**COMMENT RESOLUTION FORM**

<b>Date:</b>	1/27/2022	<b>Disposition Codes:</b>	
<b>FHU Project Number</b>	117253-08 EPC Reviews 2022	<b>A. Accept Comment</b>	<b>E. Comment Conflicts with Previous Direction</b>
<b>Project Name:</b>	Briargate Blvd over Sand Creek Bridge	<b>B. Delete Comment</b>	<b>F. Designer to Evaluate Comment</b>
<b>Project Number:</b>	EPC PCD CDR2113	<b>C. Clarify Comment</b>	<b>G. Discuss Comment; Follow-up Required</b>
<b>Client:</b>	El Paso County	<b>D. Disagree with Comment</b>	
<b>Designer:</b>	Kiowa Engineering Corporation		
<b>Submittal:</b>	1/03/2022 Plans; 12/6/2021 Sand Creek Drainageway Design Report; 1/29/2021 Subsurface Soil Investigation	<b>Other Review:</b>	N/A

**C302**

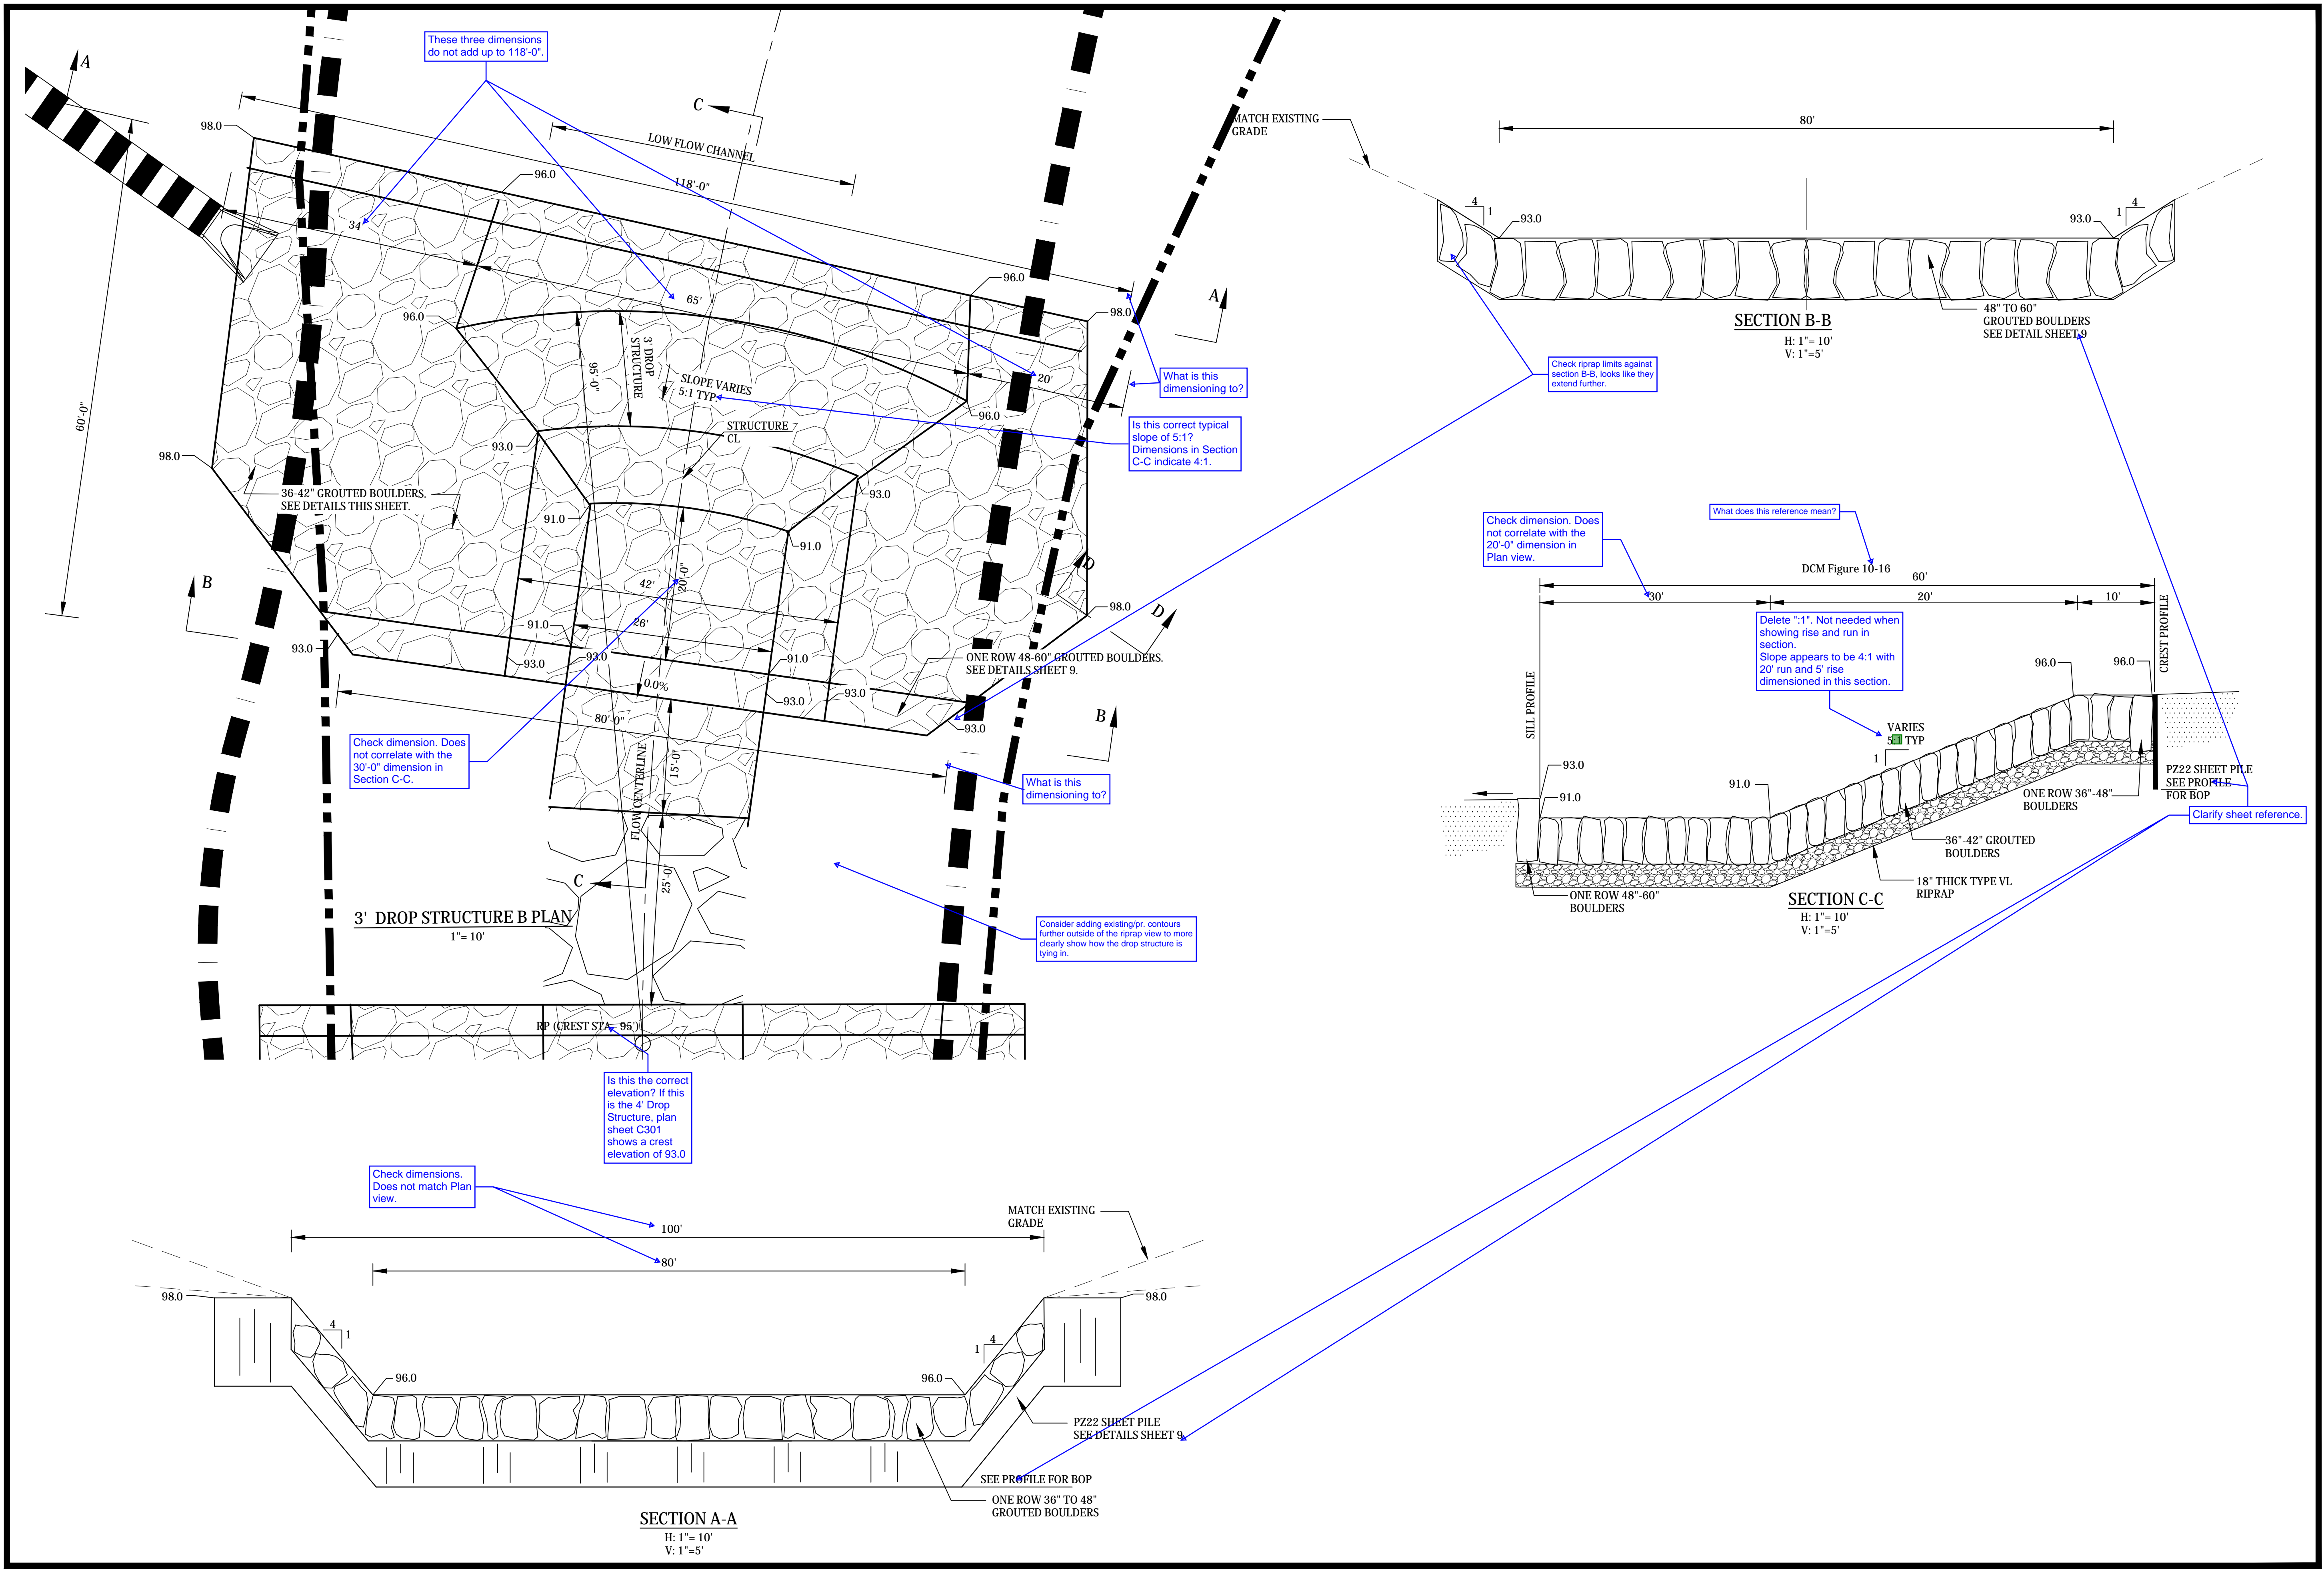
59	CAO	C302	Check dimensions. Does not match Plan view.						
60	CAO	C302	Check dimension. Does not correlate with the 20'-0" dimension in Plan view.						
61	CAO	C302	Delete ":1". Not needed when showing the rise and run in section. Slope appears to be 4:1 with 20' run and 5' rise dimensioned in this section.						
62	CAO	C302	Clarify sheet reference.						
63	CAO	C303	Sheet pile size? What is total length needed?						
64	CAO	C303	Does not match either crest elevation on Sheets C301 & C302.						
65	CAO	C303	Where is this section cut? Is this intended to be a detail blow up of part of Section C-C on sheets C301 & C302?						
66	CAO	C303	This is shown on Sheet C301. Why repeat here?						
67	CAO	SSI Report Page 2 & 5	Recommend updating to add language for the final bridge type. Report mentions in multiple places that a vehicle bridge with H-pile foundations will be constructed.						
68	CAO	SSI Report Page 7	CDOT requires LRFD design.

78	KMG	C302	Consider adding existing/pr. contours further outside of the riprap view to more clearly show how the drop structure is tying in.						
79	KMG	C303	This riprap is not shown on the drop structure details.						
80	KMG	Bridge Design Report, page 4	only the 100-year summary is provided in the appendix
